Rezoning Transportation Analysis

Petition Number: 2020-038

General Location Identifier: Tax ID 20143102

Date	Description
04-22-2020	First Review
05-19-2020	Second Review
06-25-2020	Third Review

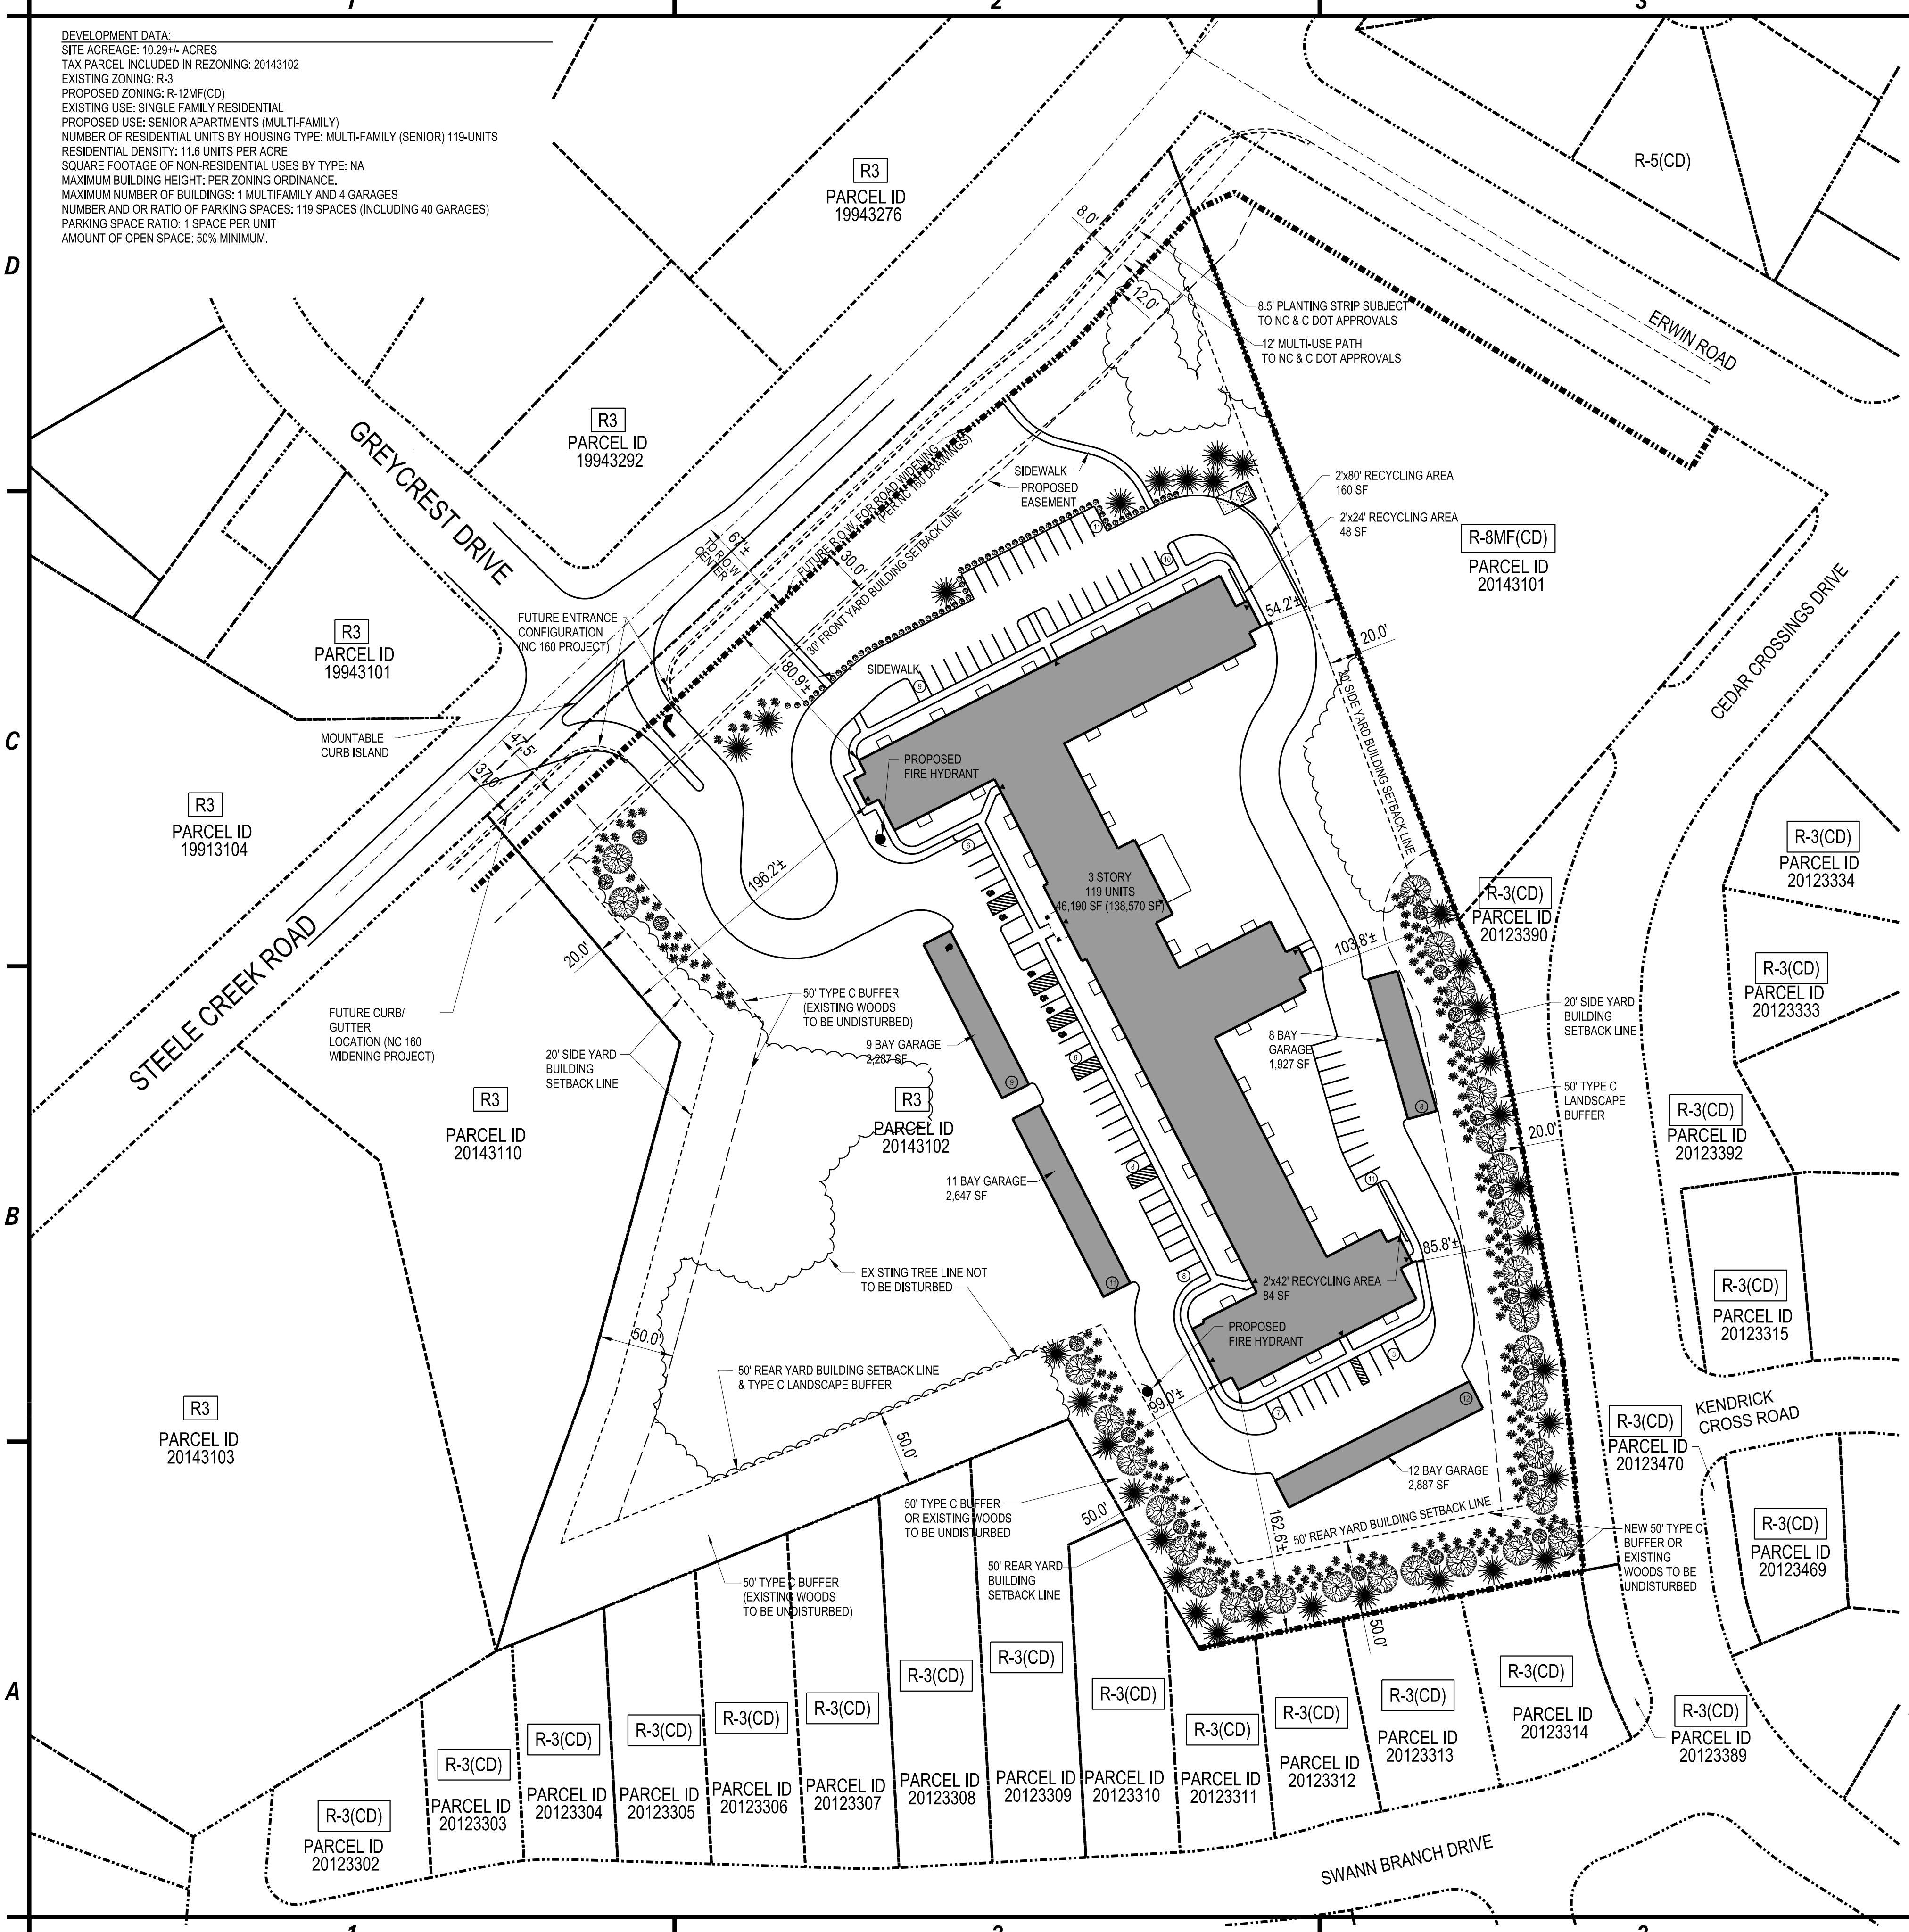
3. The petitioner should revise the site plan and conditional note(s) to commit to dedicate right of way from the road centerline for the NCDOT TIP Project (U-5766) NC 160. You can contact NCDOT for the exact location of the curb and gutter. The site plan should label and dimension the right-of-way from the road centerline.
 - a. ~~**New Comment based on revised site plan dated 4-1-2020:**~~ Please review the NC 160 cross section provided below to revise the site plan to include the correct curb line and right of way location.
 - b. ~~**Technical Clarification based on revised site plan dated 6-23-2020**~~ Please revise the site plan to revise the proposed right-of-way dedication to +/- 60 feet, measured from road centerline.

Outstanding with clarifying language added The petitioner should revise the site plan and conditional note (Section Transportation.7.) to commit to a north-eastbound 100' right-turn lane into the from NC 160 into the proposed access point. It is an NCDOT requirement.

5. **Outstanding with clarifying language added** The petitioner should revise the site plan and conditional note ([Section Transportation.7.](#)) to commit to construct a **south-westbound** left-turn lane with 150' of storage and appropriate left-turn lane tapers based on the speed limit.

6. **Outstanding with clarifying language added** The petitioner should revise the site plan and conditional note ([Section Transportation.3.](#)) to show an exhibit showing **temporary** full access with left-turn **and** right-turn lanes, and the future access on NC 160, based on the NCDOT NC 160 widening project. A conditional note should be added that the access **will may** be changed to a **right-in/right-out access** based on the NCDOT project. **Please coordinate with NCDOT and provide the future permanent access that will be permitted for the NC 160 project. For the NC 160 pre-build condition, the proposed driveway design should be reconfigured to a Charlotte Land Development Standard Manual (CLDSM) or NCDOT driveway standard, and the proposed driveway monolithic median should be removed.**

11. **Outstanding with clarifying language added** The petitioner should revise ~~the site plan to add a~~ conditional note ([Section Transportation.2.](#)) specifying dedication and fee simple conveyance of all

rights of way to NCDOT ~~the City~~ before the site's first building certificate of occupancy is issued. ~~CDOT requests right of way set at 2' behind back of sidewalk where feasible.~~

12. **Outstanding with clarifying language added** The petitioner should revise the site plan to add a note specifying all transportation improvements will be approved and constructed before the site's first building certificate of occupancy is issued. The petitioner may phase transportation improvements if said improvements and phasing are explicitly described in site plan notes. **Please include within conditional note (Section Transportation.6.) that the right and left-turn lanes on NC 160 will be constructed prior to the first CO.**
13. **Resolved** ~~Sample format for comment that is resolved~~
